**KIRKLEES METROPOLITAN COUNCIL
INVESTMENT & REGENERATION SERVICE**

DELEGATED DECISION TO DETERMINE PLANNING APPLICATIONS

Reference No:	2024/62/92850/E
Site Address:	239, Staincliffe Road, Dewsbury Moor, Dewsbury, WF13 4RQ
Description:	Erection of detached dwelling
Recommending Officer:	Nina Sayers

DECISION - REFUSED

Rev	Revision	Date
<b>JOB</b>		
PROPOSED CONSTRUCTION OF DETACHED DWELLING		
<b>ADDRESS</b>		
LAND AT SIDE OF 239A Staincliffe Road DEWSBURY WF13 4RQ MR RASHID QAYOOM		
<b>DATE</b>	<b>SCALE</b>	<b>SHEET</b>
25.09.2024	1:100	4@A3

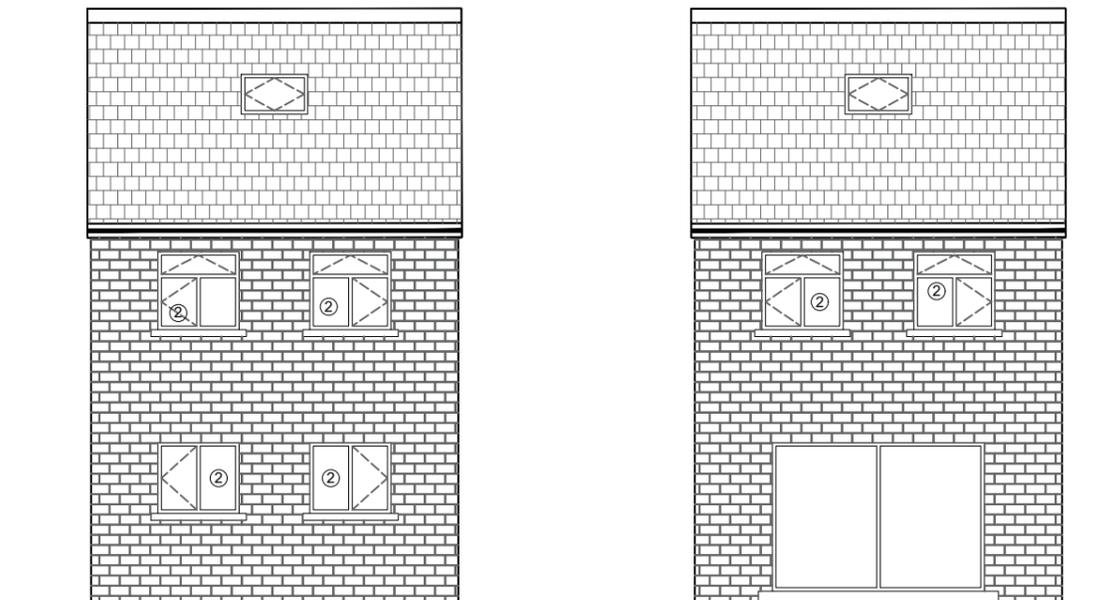
The scheme proposes a pitched roofed detached dwelling oriented with the roof face sloping towards the highway. The doorway would be on the side elevation. The proposed design does not appear to draw from the design of the existing dwellings in the street so would not be in keeping with the wider street scene. Whilst the adjacent 247 and 249 do have pitched roofs, the proposed dwelling is significantly deeper than the existing adjacent dwellings and therefore the roof pitch would not match the existing dwellings. No street scene has been provided however based on the information available to officers, the proposal would appear incongruous within the wider street scene. The front elevation would have limited architectural detailing and therefore would not contribute towards the visual amenity of the wider street scene.

It is therefore considered that the proposed dwelling, by virtue of design, would not be in keeping with the wider street scene and would appear incongruous within the street scene at the detriment of visual amenity. The proposal therefore fails to accord Policy LP24 of the Kirklees Local Plan, the aims of the Housebuilders Design Guide SPD and Chapters 12 of the National Planning Policy Framework.

There is one opening proposed in the northern elevation of the proposed dwelling which would front the site however this would serve a bathroom so would be obscurely glazed. This can be secured by condition should approval be recommended.

8 Knowles Hill Road is the residential dwelling to the west of the application site. The proposed dwelling would have openings in the rear (western) elevation which all serve habitable rooms. The proposed dwelling would be set approximately 3.2m from the boundary of no.8. The proposed openings, particularly those at first floor, would face directly onto the amenity space for no.8. therefore the proposal is considered to cause significant overlooking harm to the amenity of the occupiers of number 8 as a result of the proposal.
